From: Liz Jarmin [REDACTED]
Sent: 27 February 2023 09:08
To: Borough Planning <borough.planning@West-Norfolk.gov.uk>; Andy Watts
[REDACTED]
Subject: Re: 23/00007/F Sue Ryder 79 Westgate Hunstanton PE36 5EP

Subject: 23/00007/F Sue Ryder 79 Westgate Hunstanton PE36 5EP

Title:  
 SHOPFRONT DETAILS

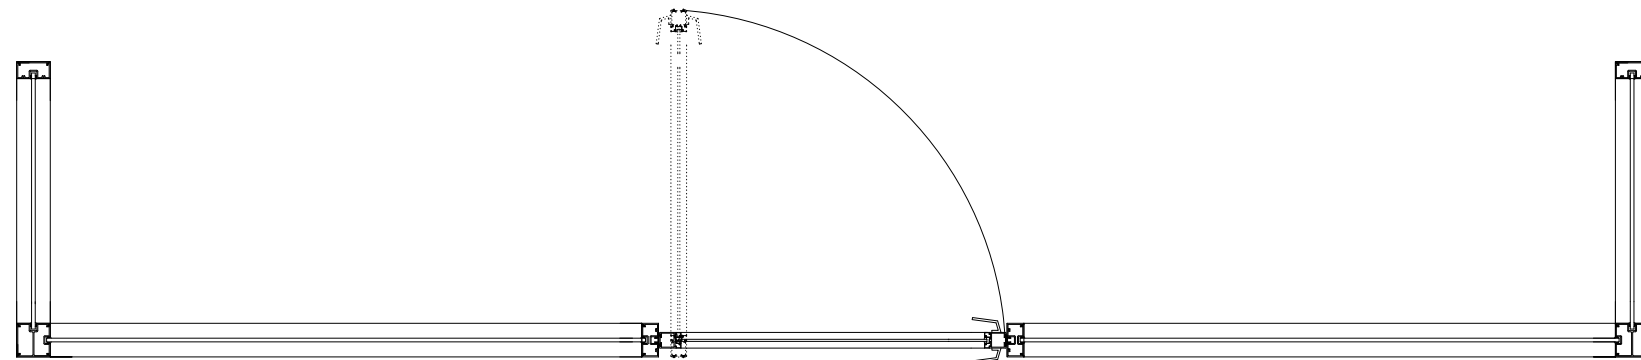
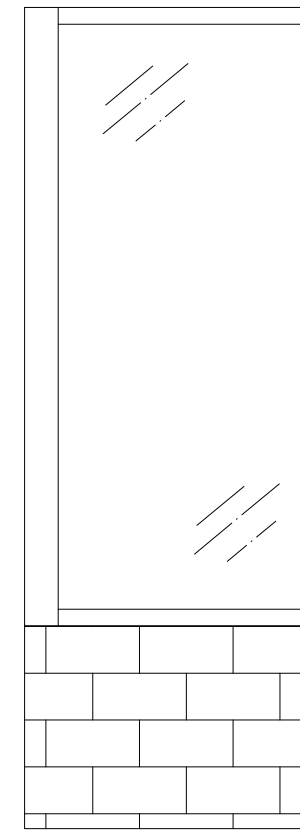
The plan states the scale is 1:20, and the width of the shop front is shown to be 4870. When I measure at 1:20 scale it comes out at 1.26

The side is shown to be 880. When I measure it is only 0.23.

I am sorry, but this plan is still not to scale. It may be the way its been saved or scanned.

I apologise for this. The application is invalid as the proposed plan is not to scale and I need confirmation that both side elevations are the same.
